Simon Cross - Clerk to the Council
East Preston Parish Council
Council Office
122 Sea Road
East Preston
BN16 1NN

Your Ref: OWPC26371
Our Ref: EP/28/20/CLP 11-03-2020
Please ask for:
Finlay Gardner

Lawful development certificate for a proposed side dormer & roof light.
4 Normandy Lane East Preston

Drawing Number 2020/32 Sheet 1 of 1

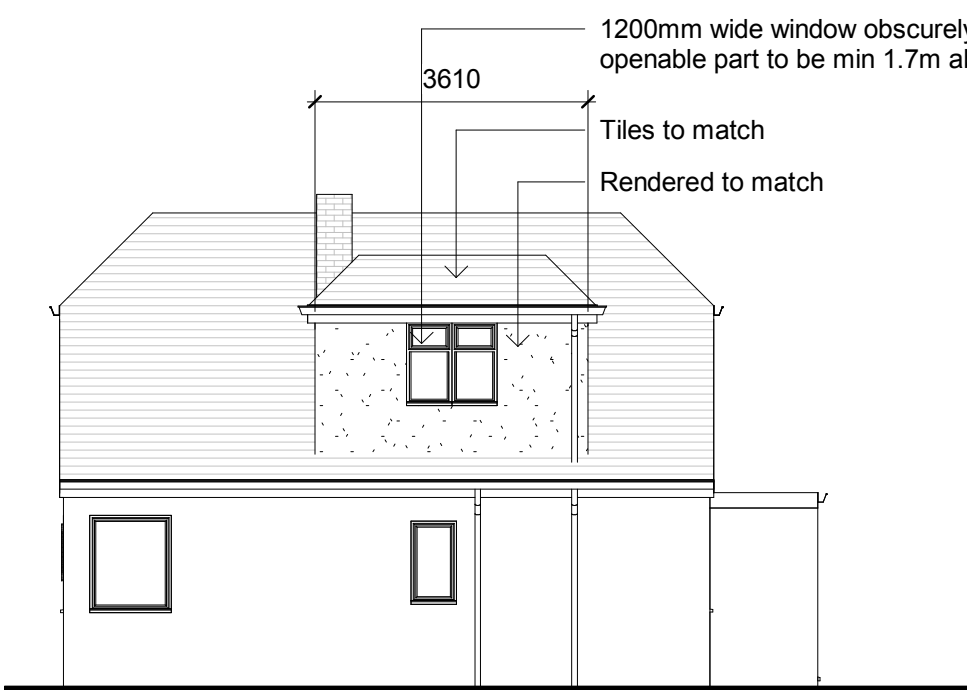
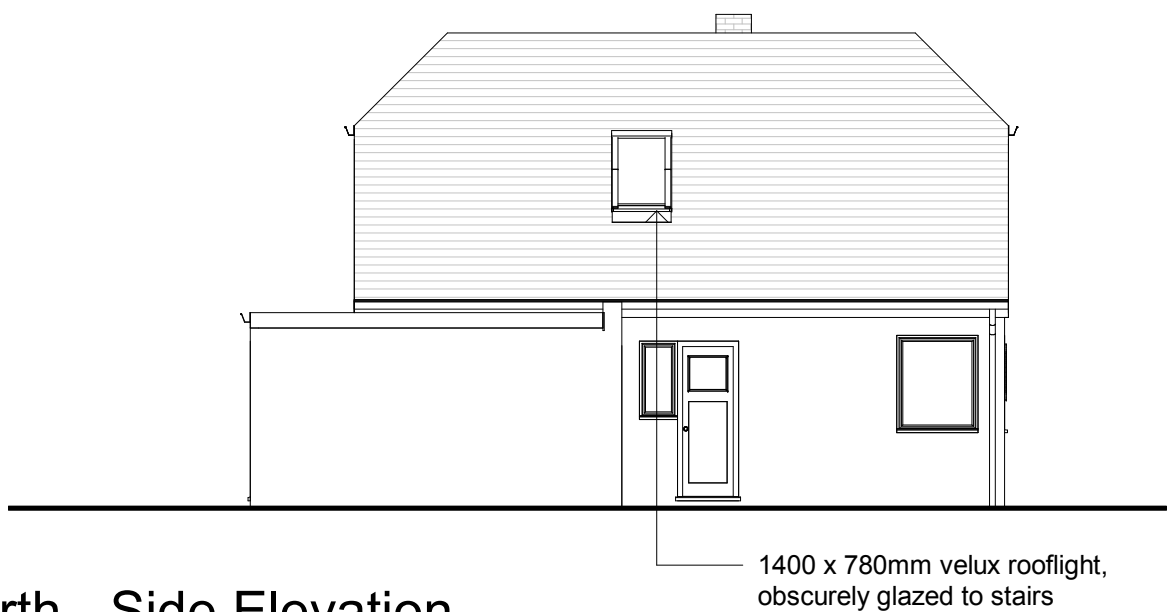
This council is concerned the proposed dormer will, from many angles, make the property look almost continuous with the property on the southern side which has a dormer extending out almost to the boundary. This would be an unacceptable change to the street scene and the spatial character of the road.
